Venbridge House, Cheriton Bishop, EX6 6HD

Design and Access Statement, Statement of Significance and Schedule of Works

December 2022 revision A

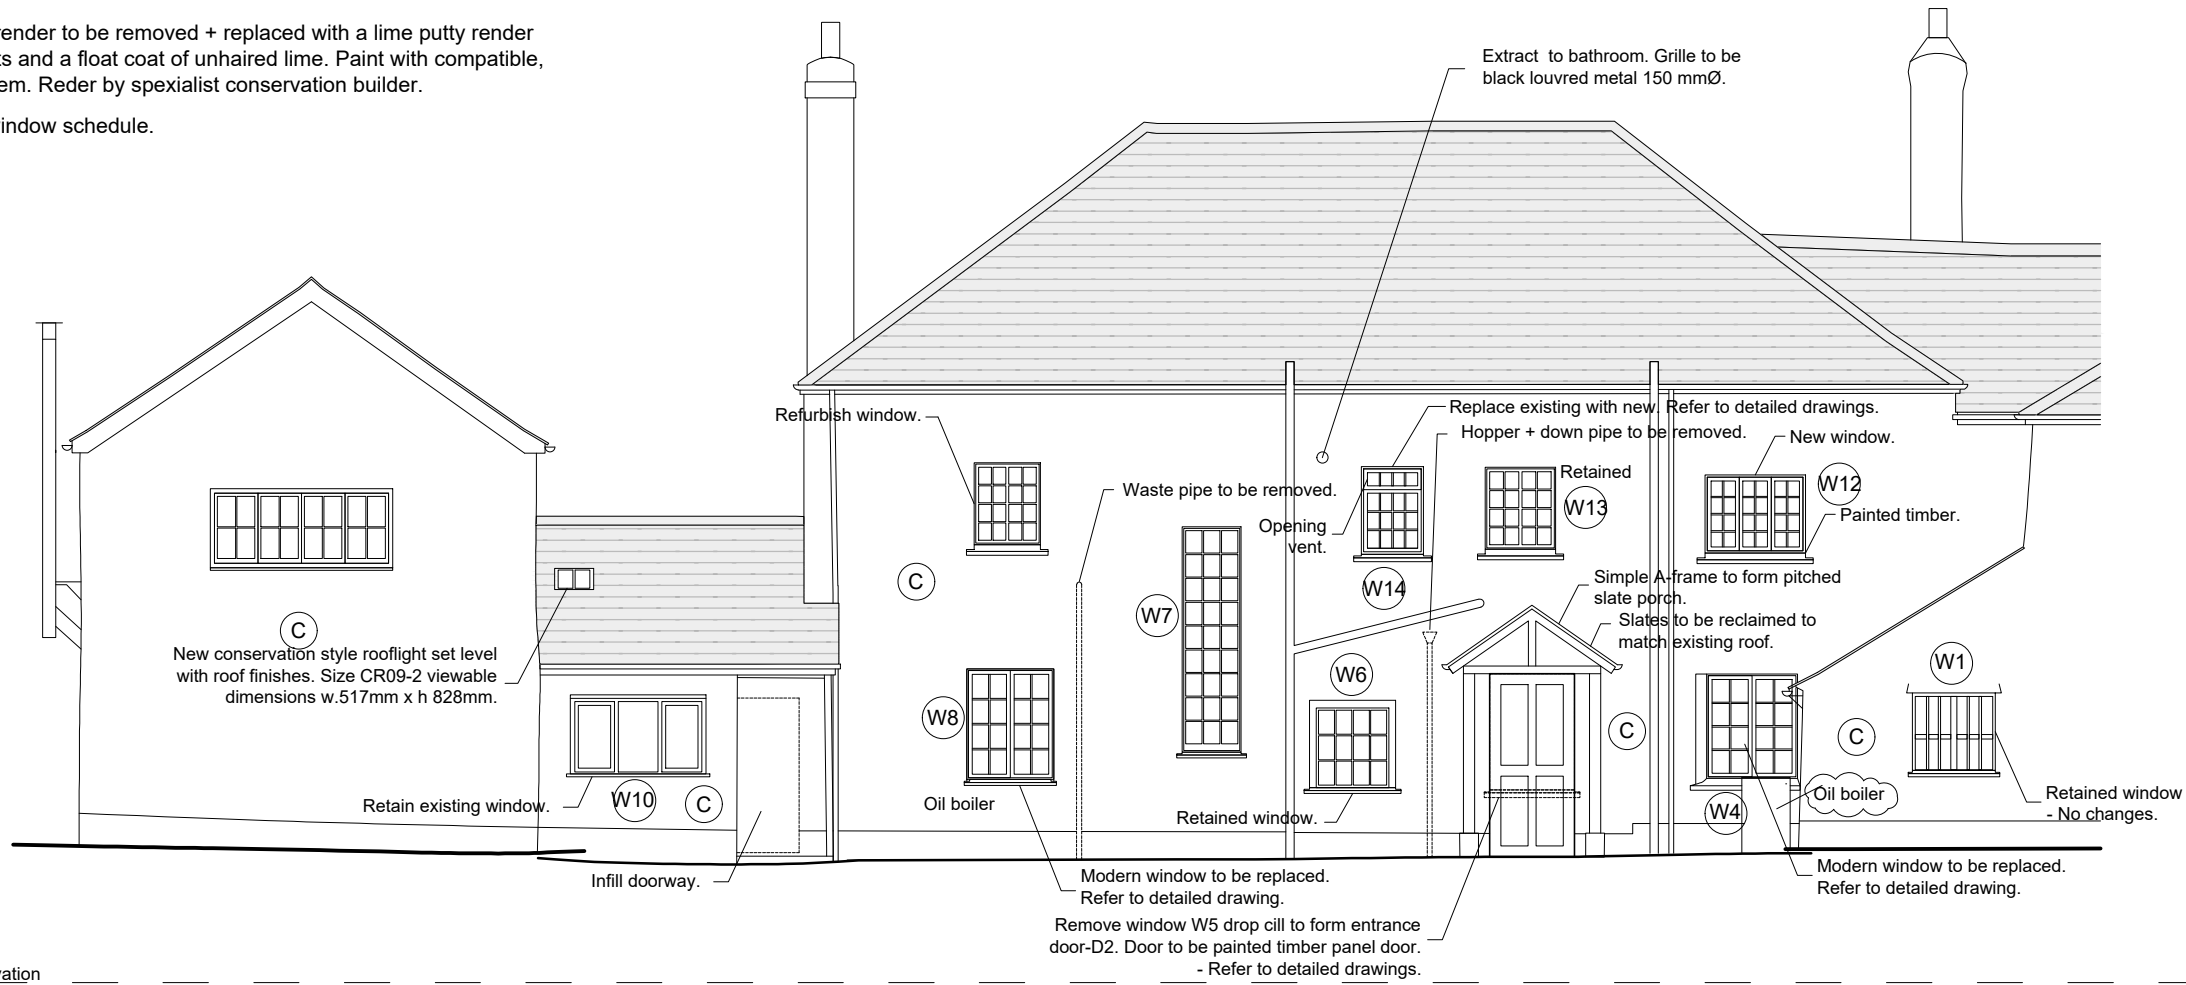
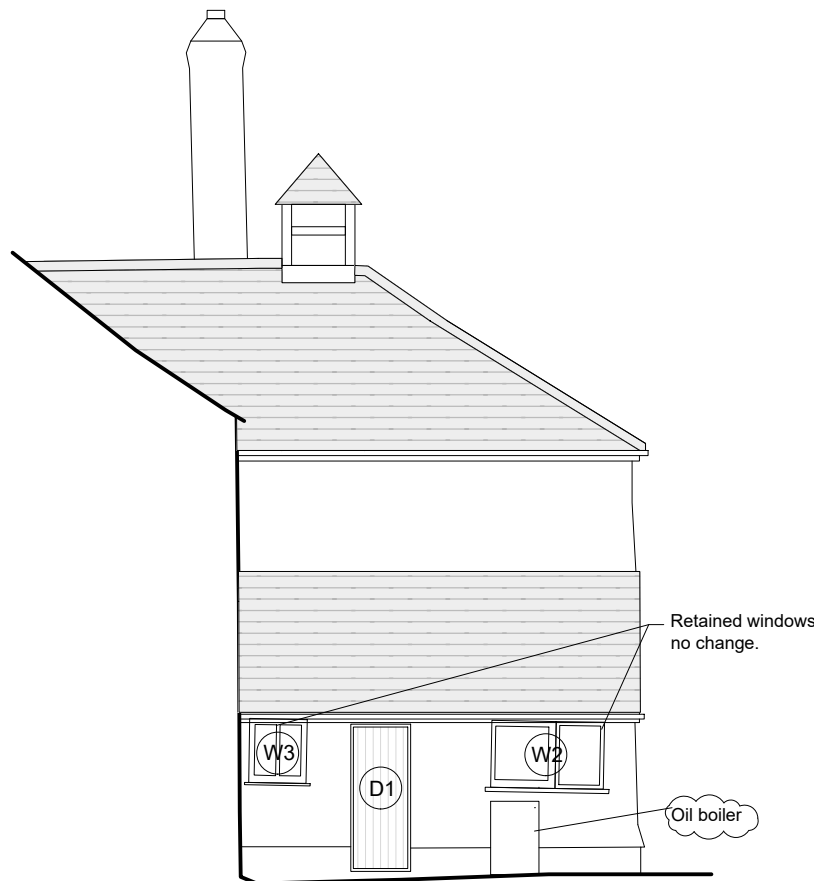
- *No objection to a French drain – care to avoid undermining of footings of cob’s stone plinth – no LBC.*
- *Replacement of existing cement render – supported – LBC required for this and installation of lime finish.*
- *Removal in strips is also recommended, in order to monitor the stability of the underlying cob.*
- *A Method Statement will be required as part of any application for the removal by hand and reinstatement and finish.*
- *Internal localised patch replastering no LBC.*
- *Large scale – LBC required.*

- b. External render: The existing cement render will be carefully removed from the entire North elevation and Annex North and West elevations and replaced with a lime putty render with haired backing coats and a float coat of unhaired lime render to achieve the contours of the wall required. External paint with SecilTek silicate primer and silicate paint system or a similar compatible, breathable paint system. Undertaken by a specialist conservation builder. Quotes have been sought. NB can only be undertaken outside frost period including its curing process and must be protected from rain. Removal of cob will be undertaken in strips by hand in order to monitor the stability of the underlying cob. (Area shown with green outline on proposed ground floor plan).

- c. Internal finishes to external North wall. Failed and cement plaster to be removed from the annex external walls and the North wall of main house. Ensure wall is dry before lime putty render applied as b. Paint with breathable paint and replace skirting boards to match existing. (Area shown with red outline on proposed ground floor plan).

W12 1:10 C

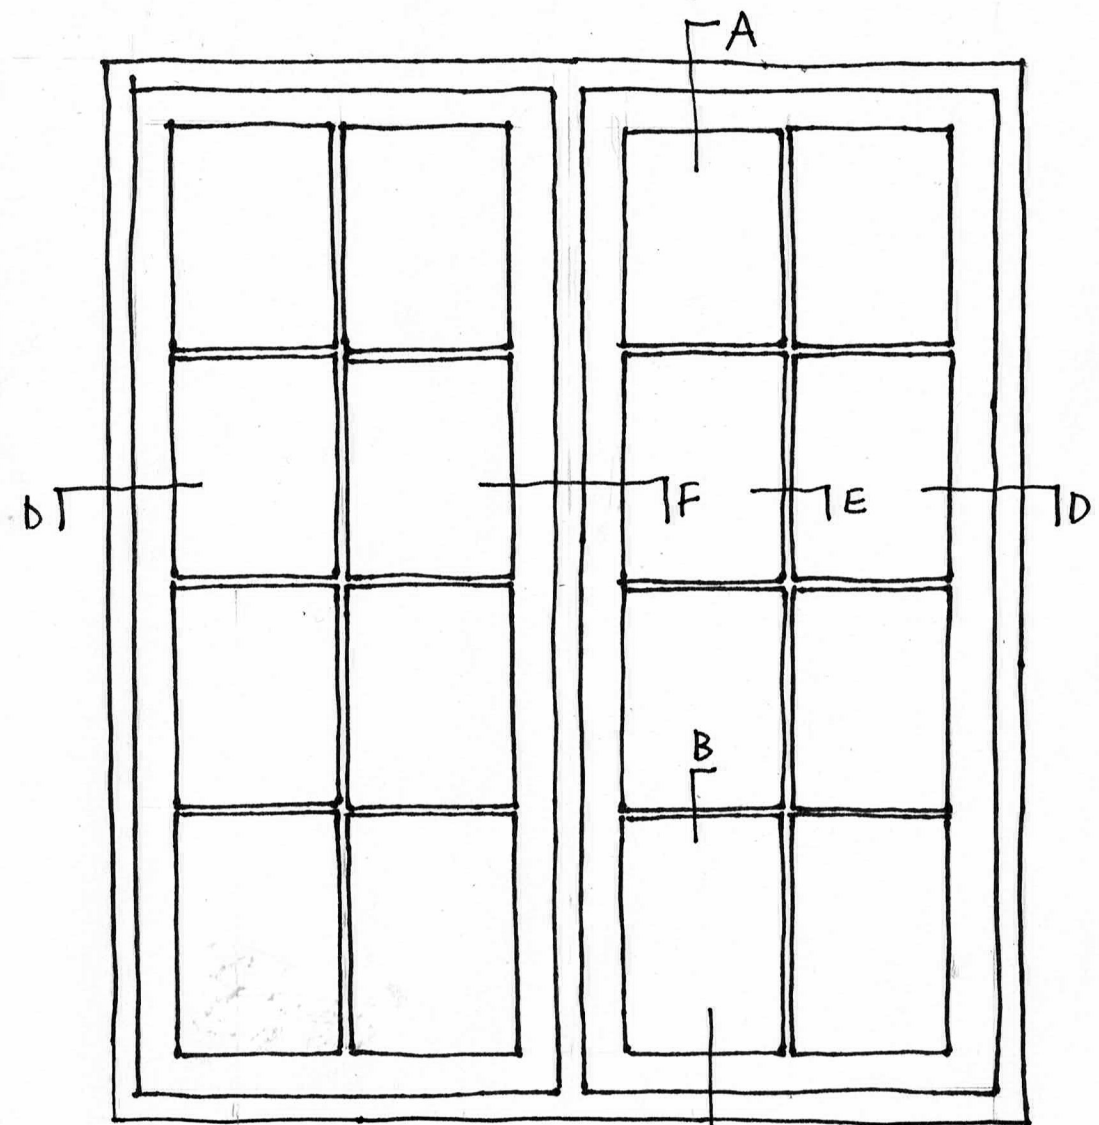
- j. W12 and W14: W14 = Modern casement timber window of unsympathetic design. W12 = aluminium window. Comment from pre-app *'at present this W12 is overly wide for a dual casement window, consideration should be given as to whether an improved dual casement*

could be achieved with thicker framing or change to a triple casement.’ Both to be replaced with double glazed casement windows.

- Both are modern and replacement is welcomed.
- At present W14 is overly wide for a dual casement window, consideration should be given as to whether an improved dual casement could be achieved with thicker framing or change to a triple casement?

Detailed joinery drawings of these windows are submitted with this application (1:20 elevation and 1:5 vertical and horizontal sections). The details show: -

- i. Flush fitting and balanced casements.
 - ii. Timber beads to match existing historically windows.
 - iii. No through glazing bars.
 - iv. Traditional profiled glazing bars.
 - v. Painted finish.
 - vi. Traditional ironmongery.
 - vii. Black spacer bars to double glazed unit.
 - viii. No trickle vents.
- k. W13: to be retained. Remedial works as required.
- l. W15: Existing. Sliding window which no longer operates. In accord with the pre-app recommendations the window will be retained and refurbished.
